CITY OF PORTLAND BUILDING PERMIT

Located At 10 OVERSET RD

Job ID: 2011-11-2778-ALTR

has permission to Revoove deckand build addition

Plan Showing Site Plan Made For  
**David L. Anderson & Karen S. Anderson**  
10 Overset Road  
**PORTLAND, MAINE**

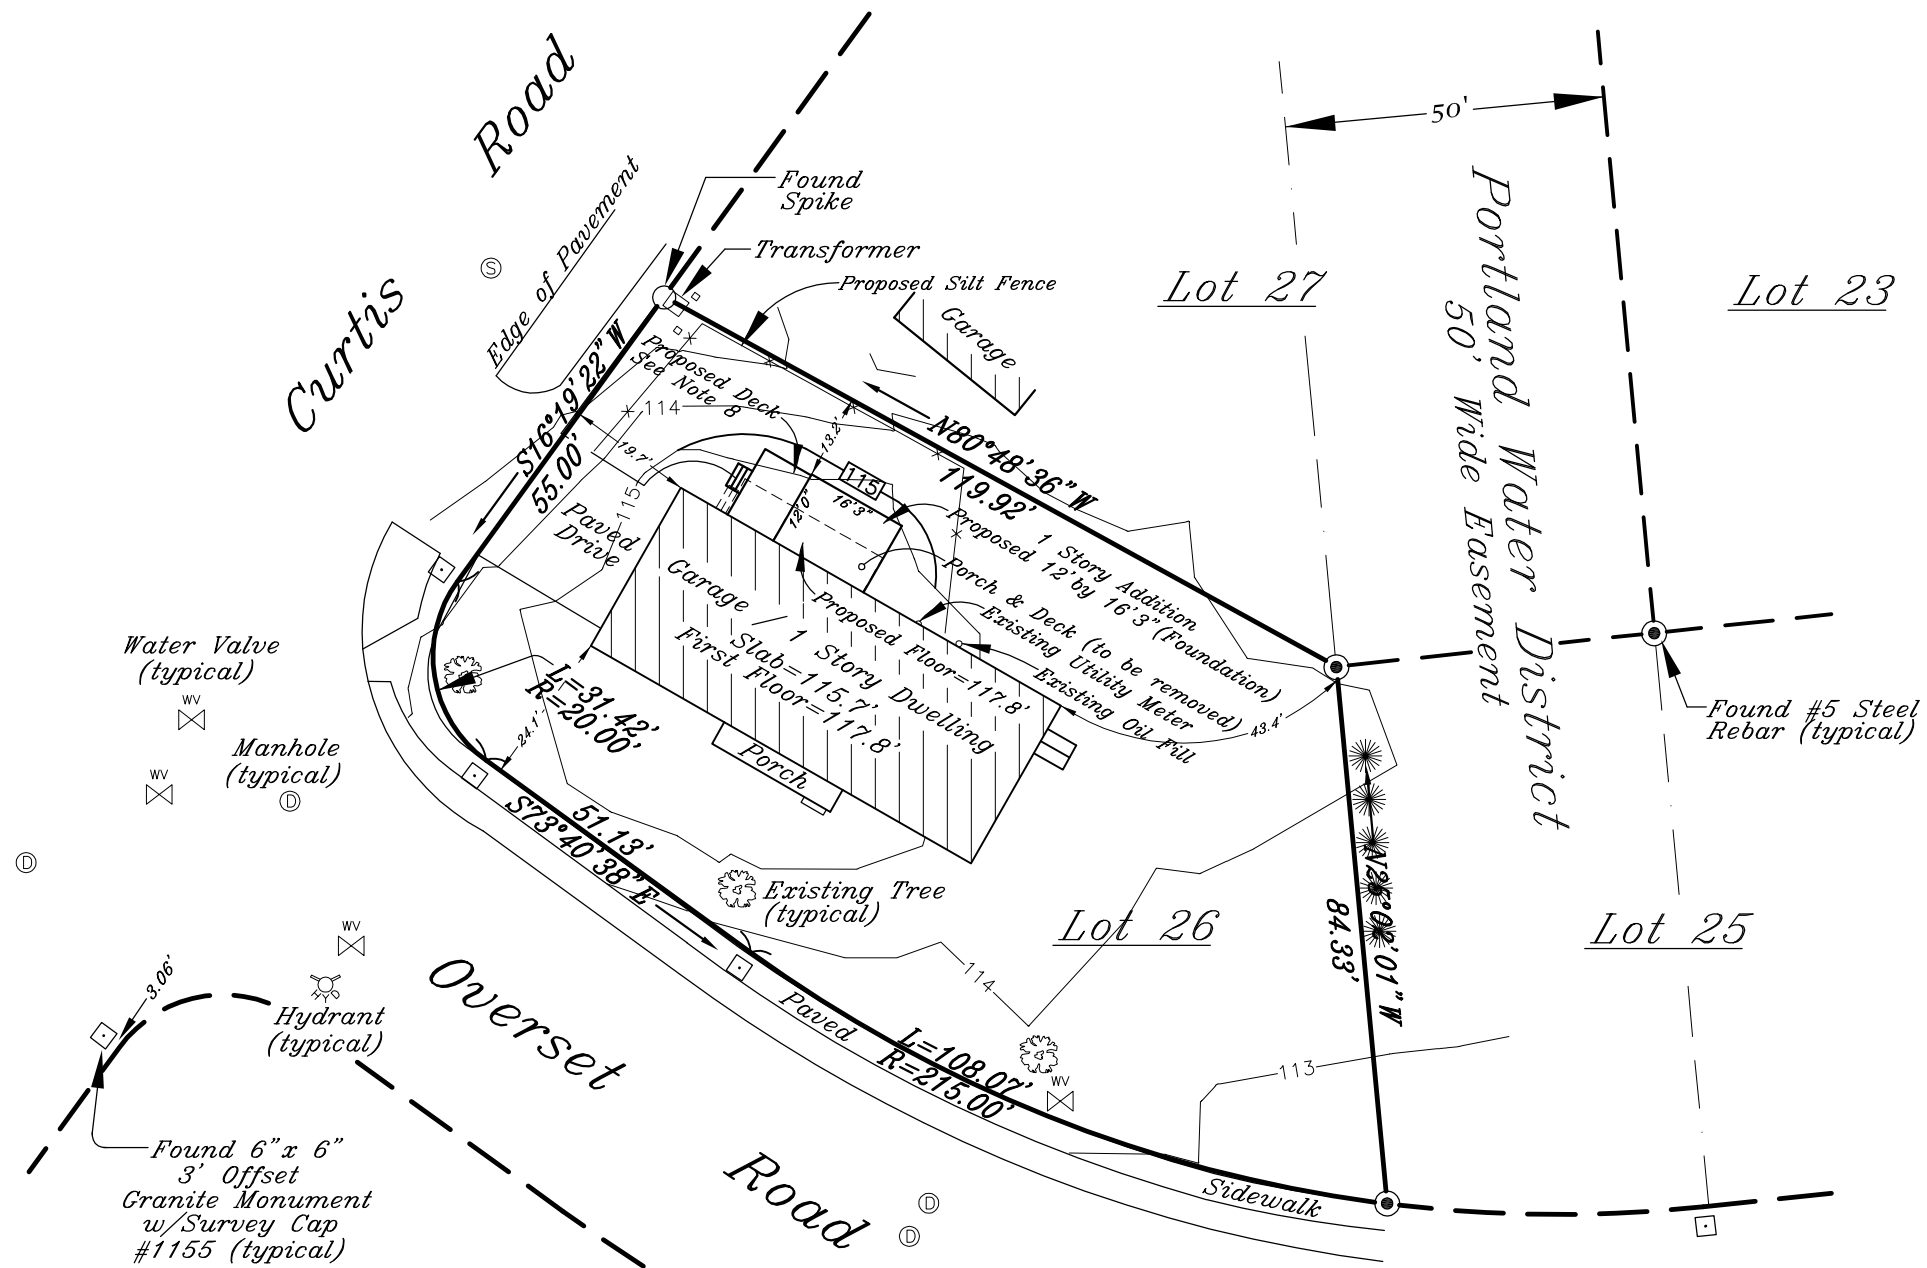
OK to allow Rear yd to meet A side yard off setback (12' min - 13.2' shown)

[R-2]
 Sideyard - 1 story - 12' min - ~~12.2'~~
 Rearyard - 25' min - 25' shown
 w/ 14-428 - 12' min under corner lot
 13.2' shown
 Front no change
